Addendum No. 2

RE: Contract ID C203394

Durham County (U-0071)

East End Connector From North Of NC-98 To NC-147

UNDERPASS LIGHTING LAYOUT

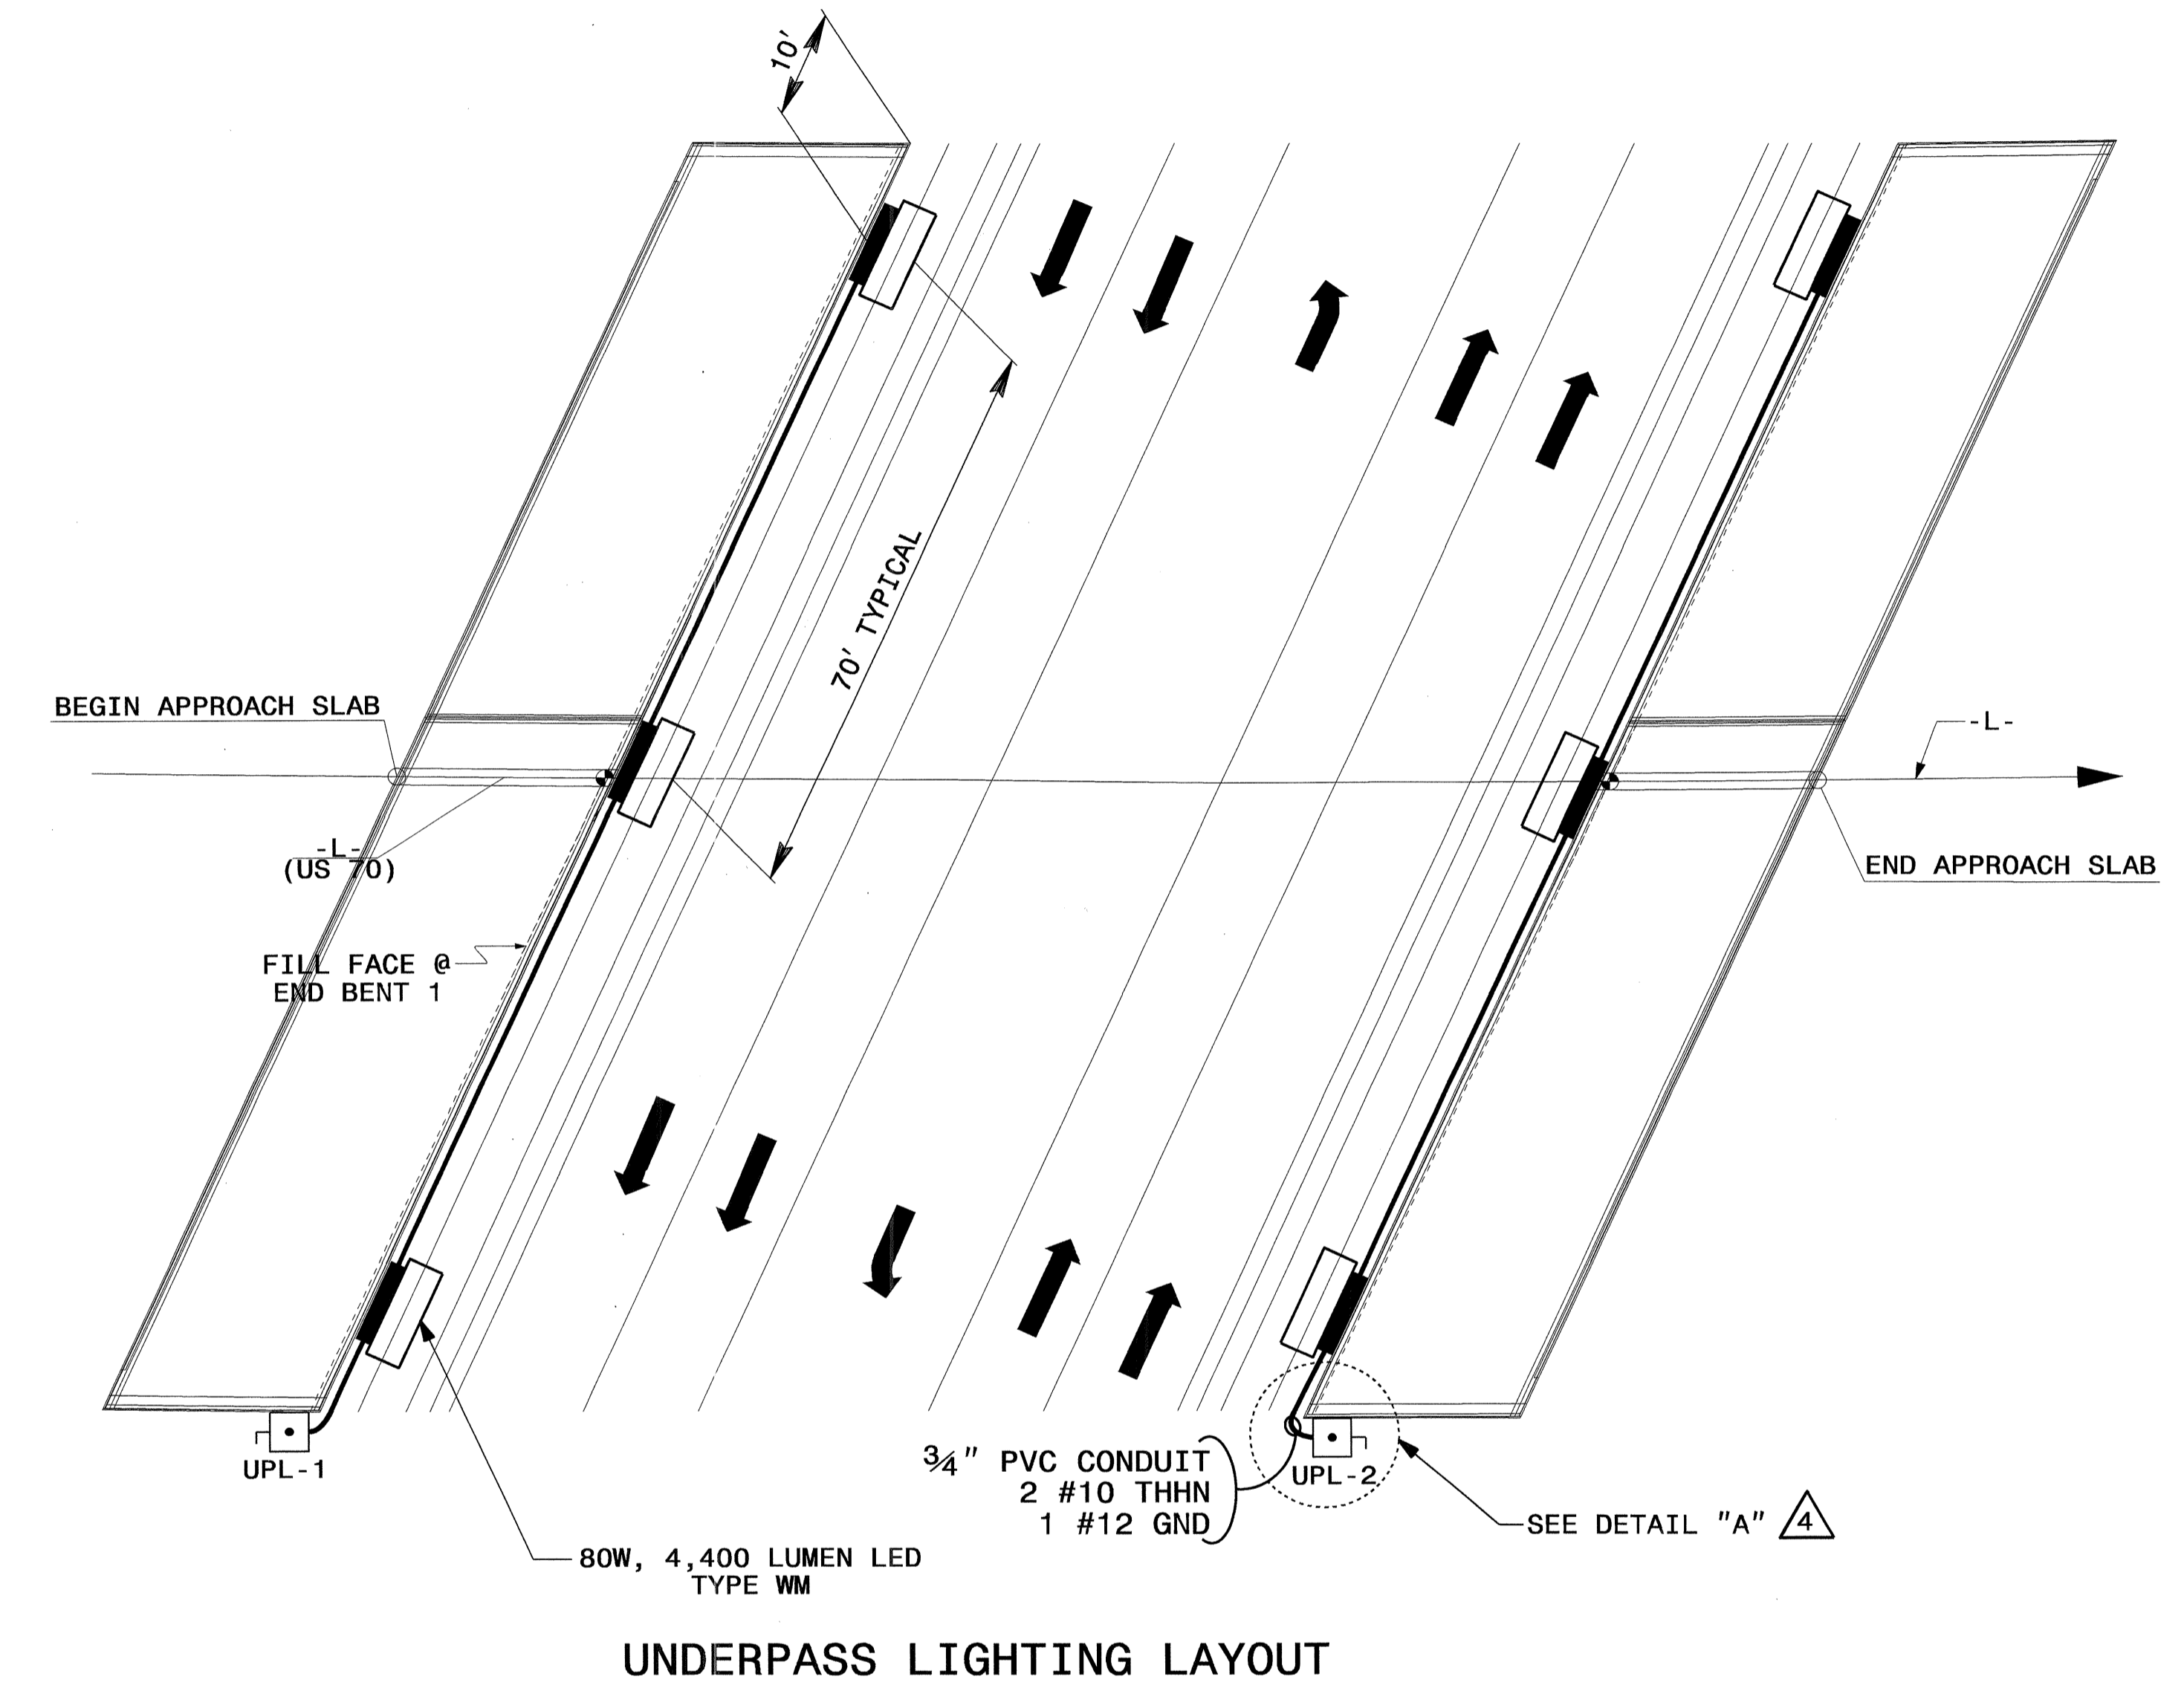
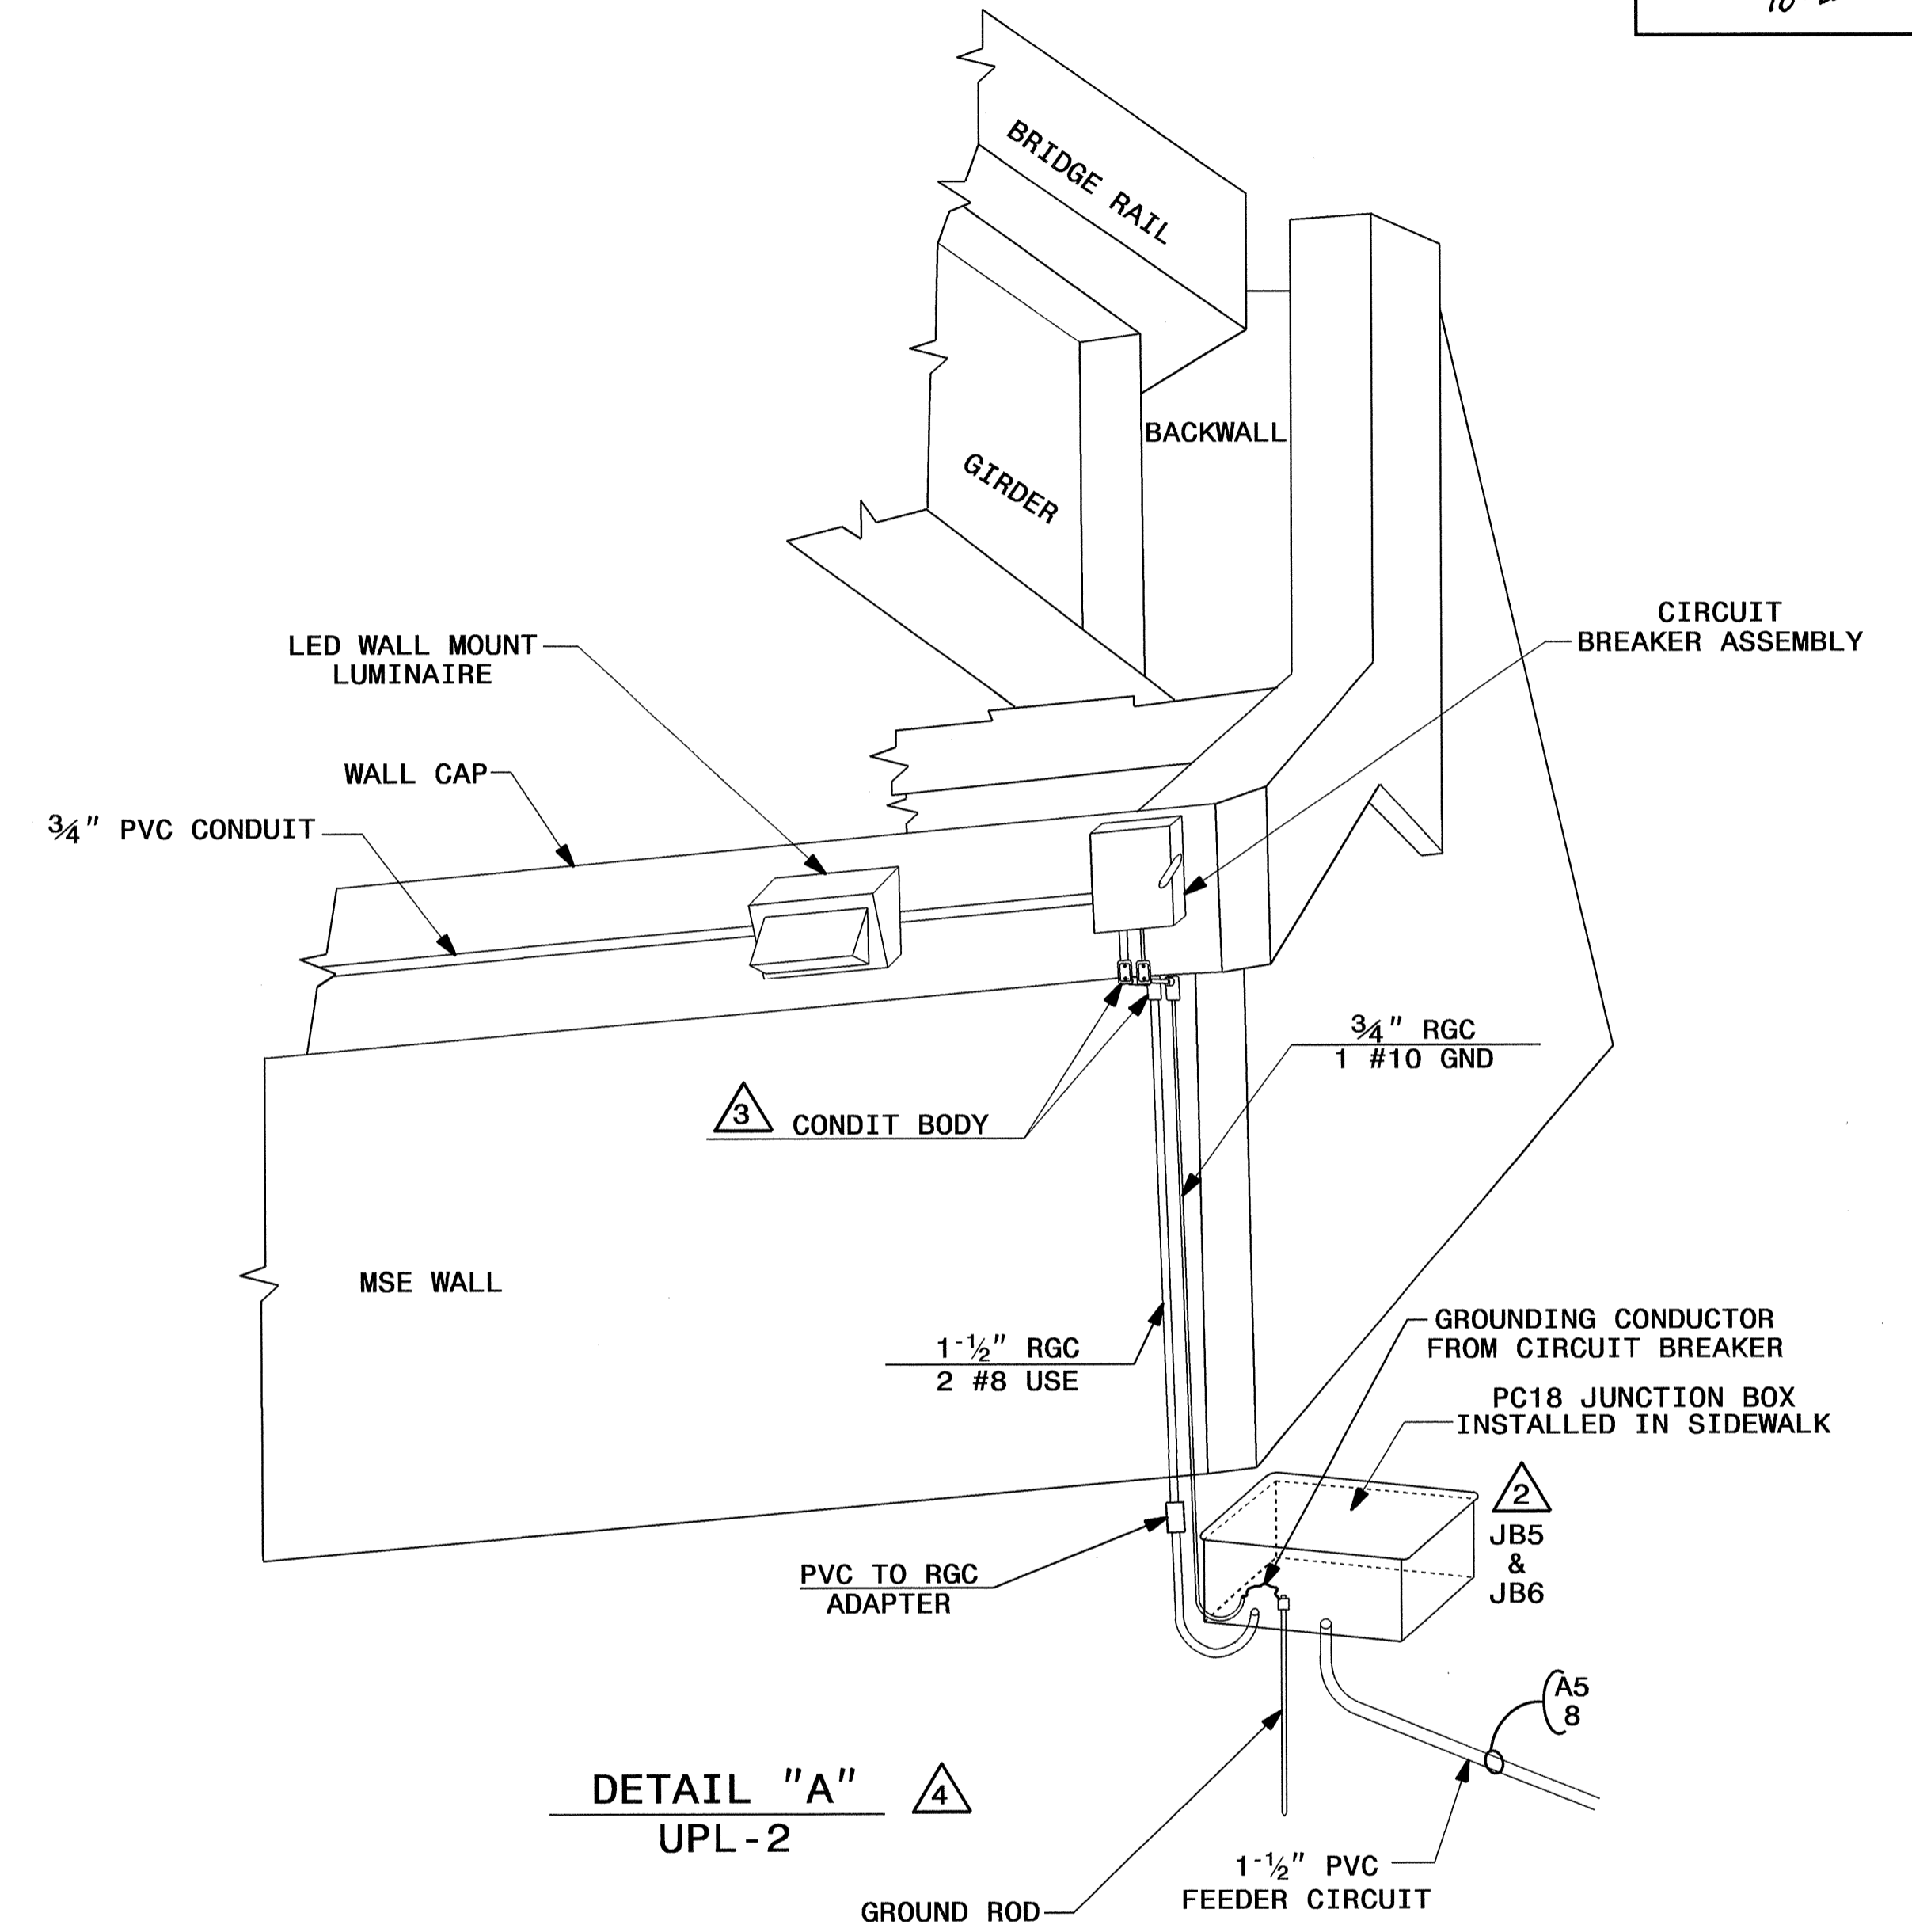
Sheet No.	Revisions
E1 thru E5	Revised to change from HPS luminaires to LED luminaires
